April 19, 2024

**Re: American Furniture Demo at 3535 Menaul Blvd NE  
Erosion and Sediment Control Plan  
Engineer's Stamp Date 4/16/24 (H16E083)**

SHEET:
9

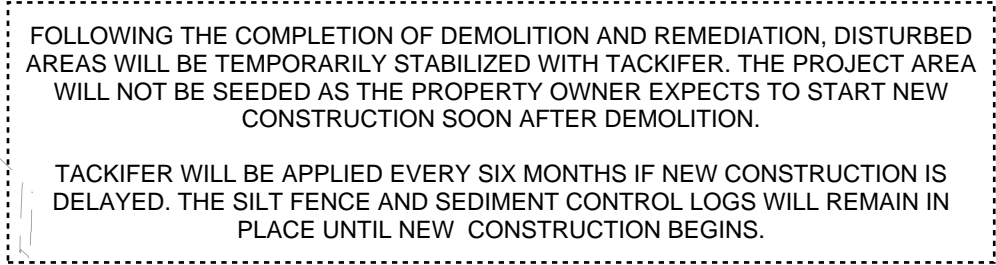
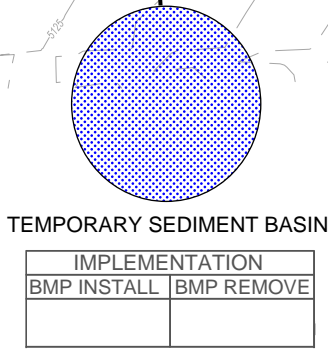
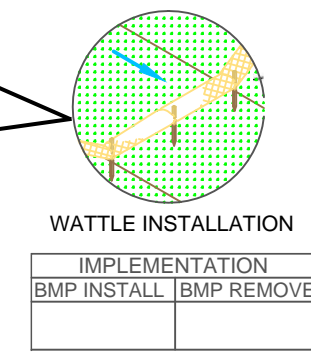
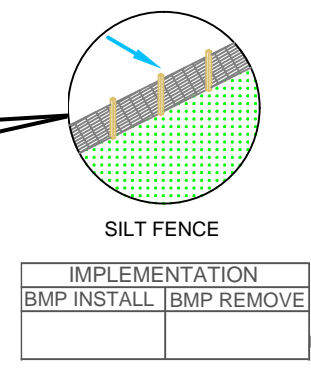
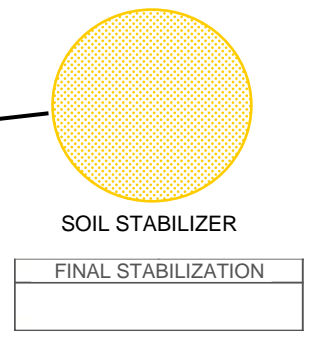
- So, change the sequence of construction notes so that the controls are the first item of construction. The notes on sheets 2, 8, and 9 must be revised to say Ponds 1 & 2 and will be constructed and operated as sediment traps during construction. The Sediment traps and the berm are the first items of construction, along with the rest of the temporary stormwater controls. Describe the nature of construction activities beginning with the initial establishment of the BMPs, posting of permit coverage, and any demolition covered by the permit. Include a description and project schedule per CGP 7.2.3.f through final stabilization, removal of BMPs, and filing NOT.

3. Provide calculations, inspection, and maintenance notes on the ESC Plan to show that the sediment traps will function according to CGP 2.2.12.
  4. Update the engineer’s stamp date each time the plan changes.
